## Appendix M - Response to Public Submissions

### The Sandstone Precinct – SSD 6751 MOD 2 and SSD 7484

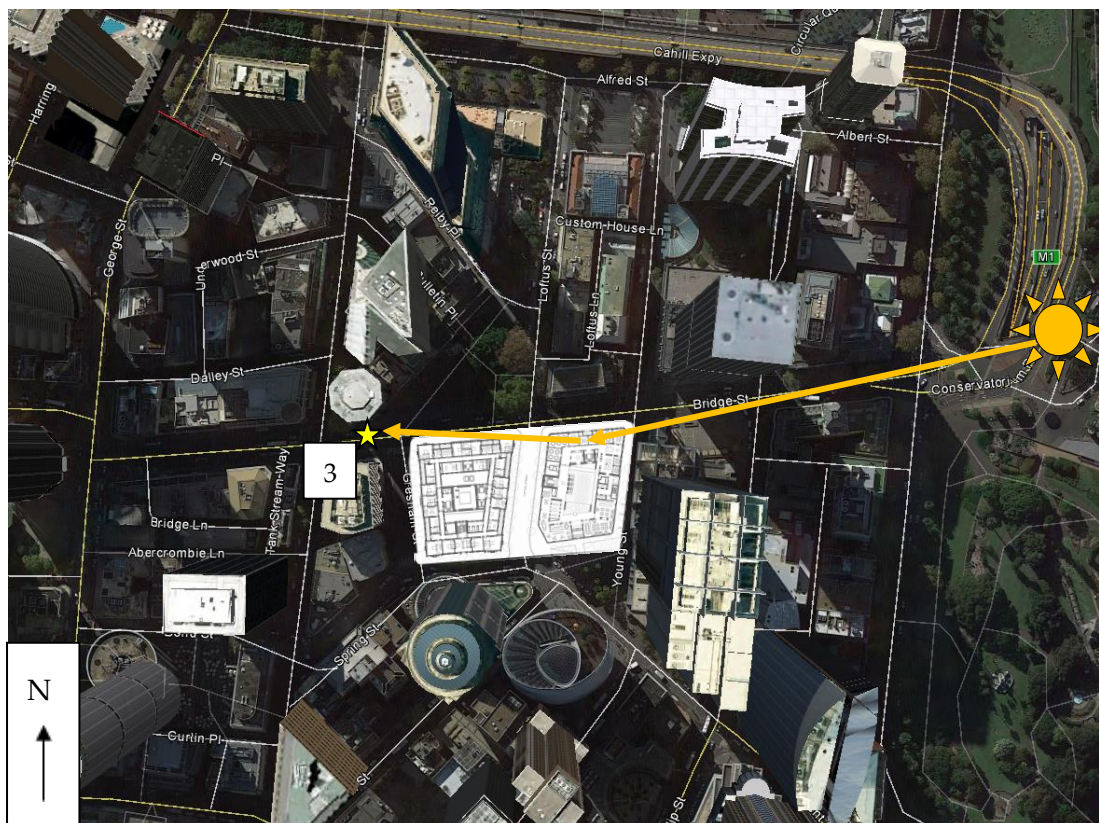
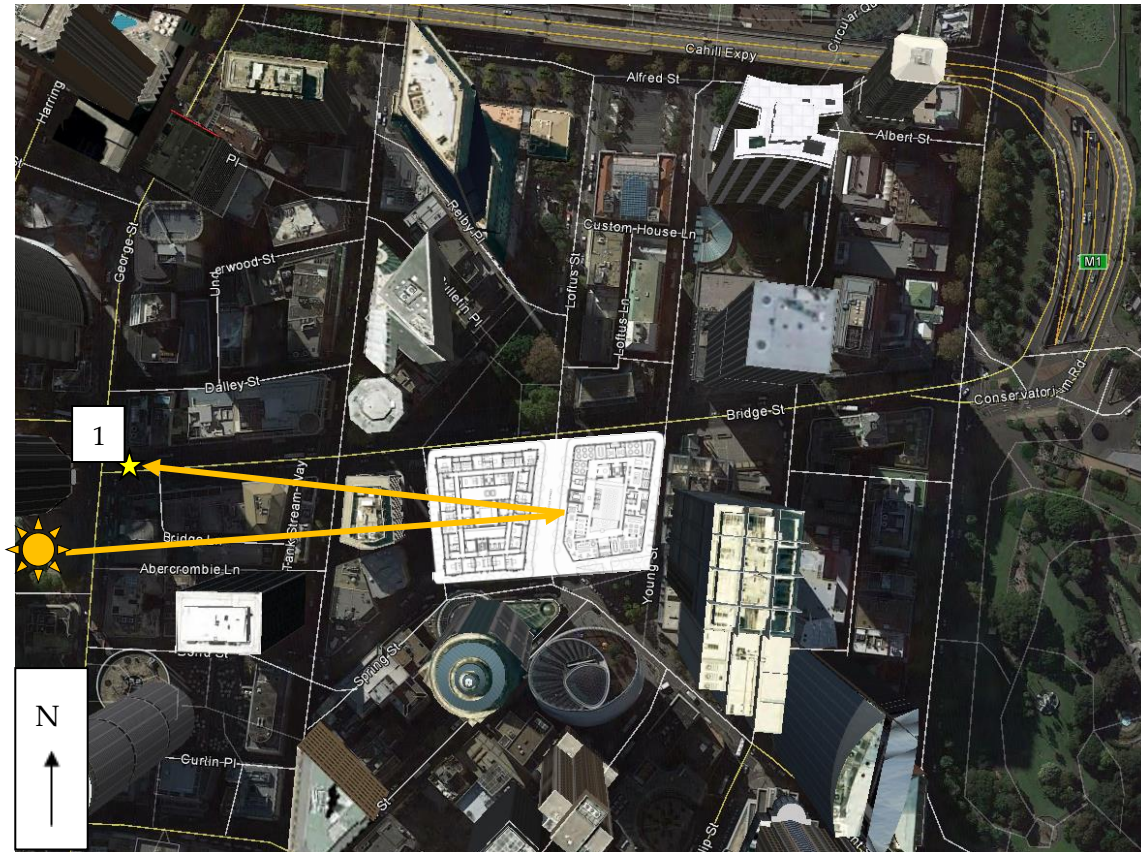
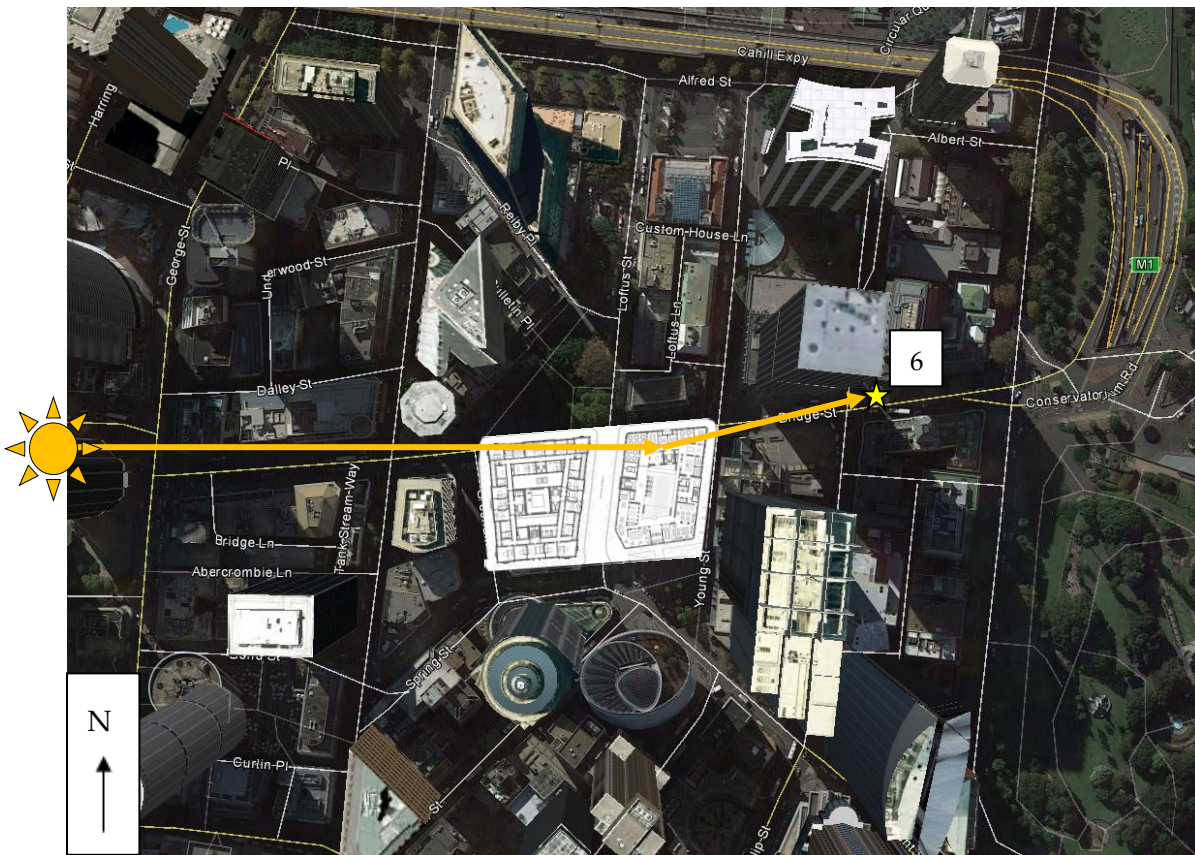
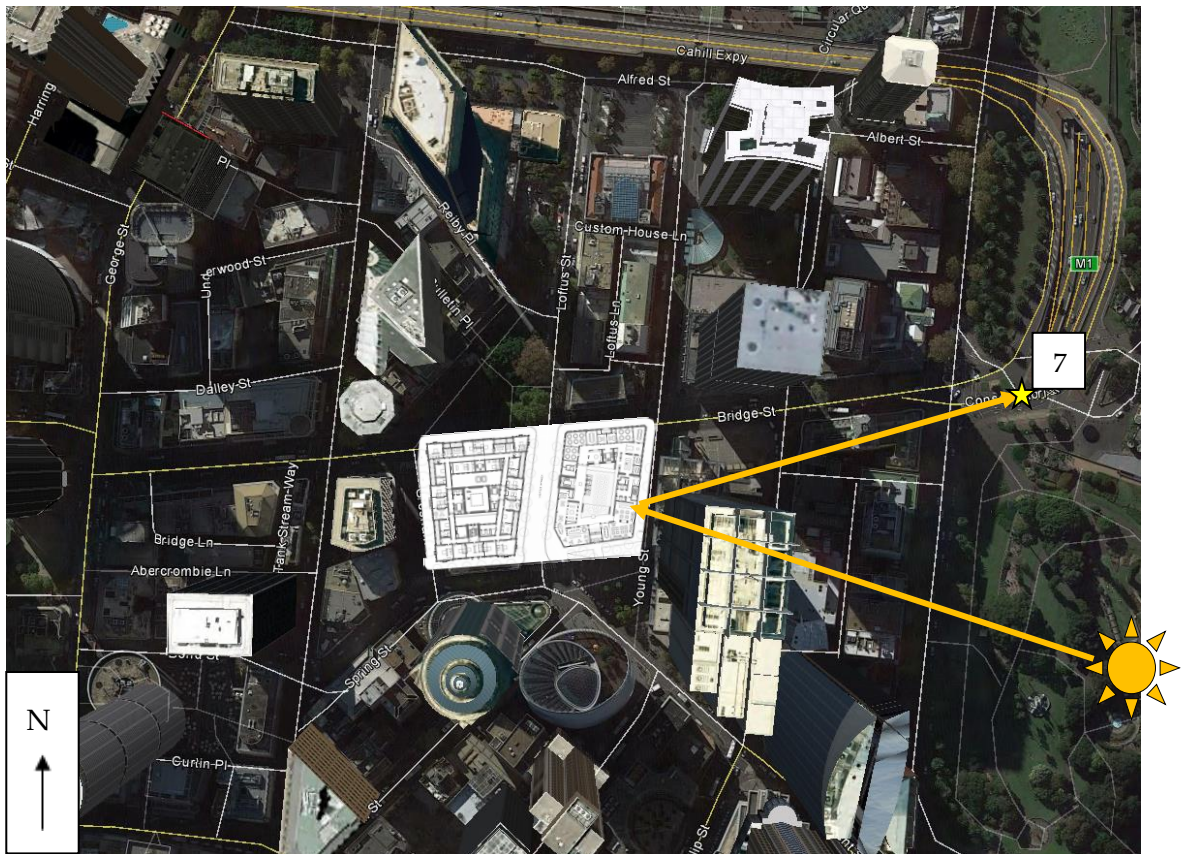
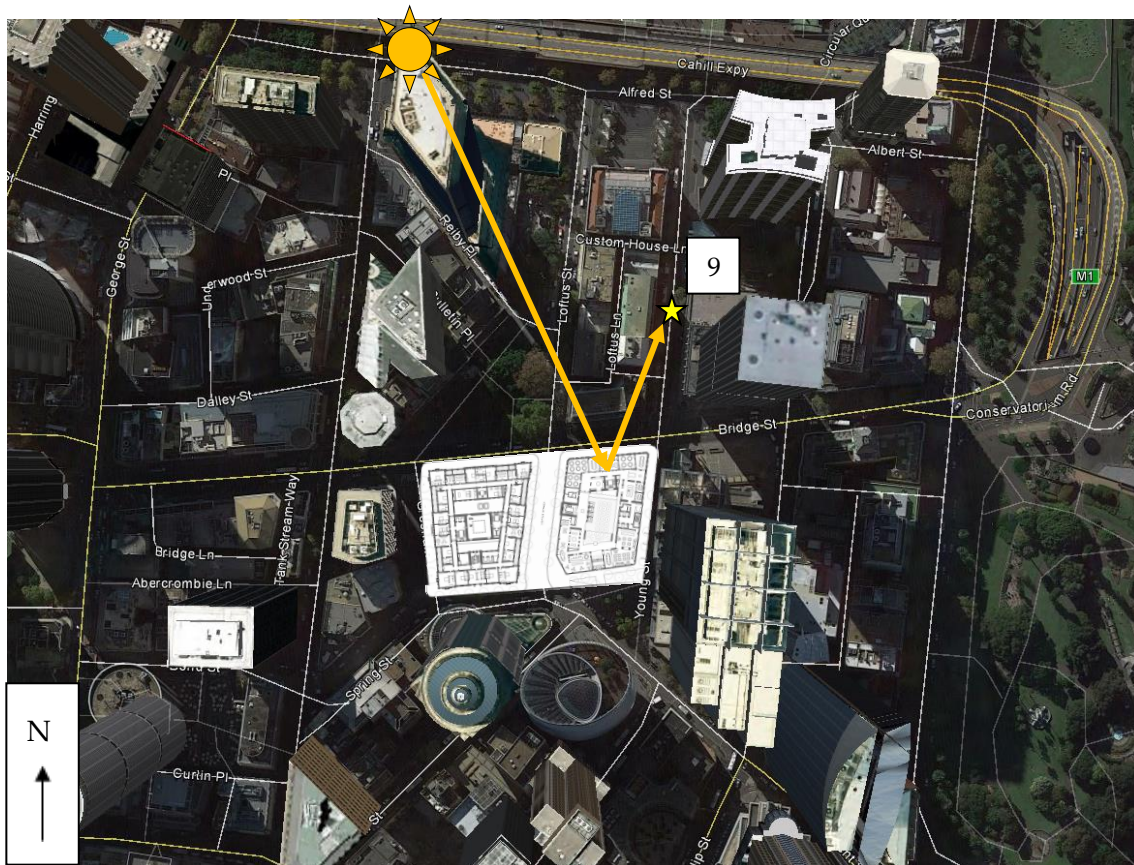
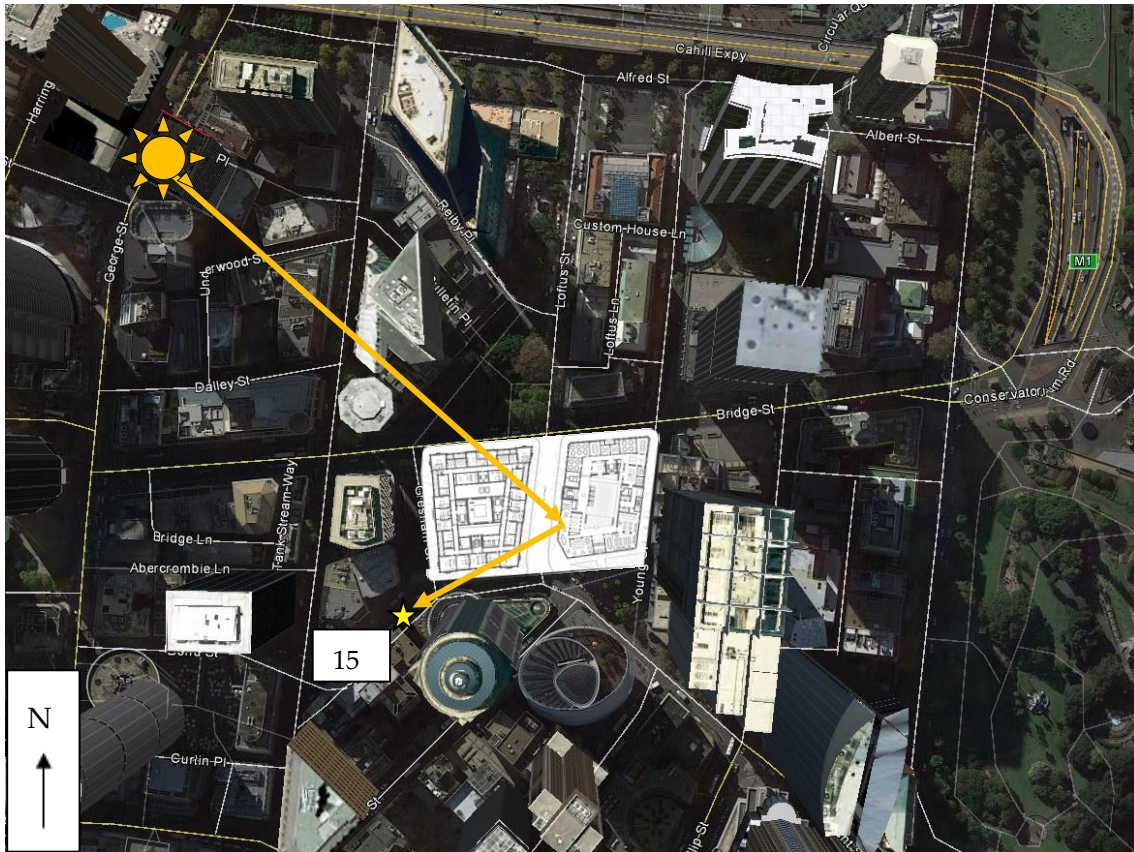
<ul style="list-style-type: none"> <li>Potential for reflective glare from the glass-fronted additions to the Education Building. Would like assurance that there will not be blinding light reflected into the property from the sun.</li> </ul>	<p>An assessment of solar reflectivity has been undertaken by CPP at Appendix W of the EIS. The assessment is consistent with the requirements of Sydney DCP 2012 for the assessment of specular and diffuse reflections emanating from proposed developments. The assessment includes consideration of diffuse reflection from the Lands Building which found:</p> <p><i>"The diffuse solar reflections that will emanate from the convex surfaces of the proposed rooftop glazing on the Lands Building will, by definition, diverge into different directions and continually shift throughout the day. The divergent natures of the solar reflections are considered less substantial than direct solar reflections from flat surfaces, or concave surfaces, since divergent solar reflections are not concentrated in one direction and do not last over a long period of time."</i></p>
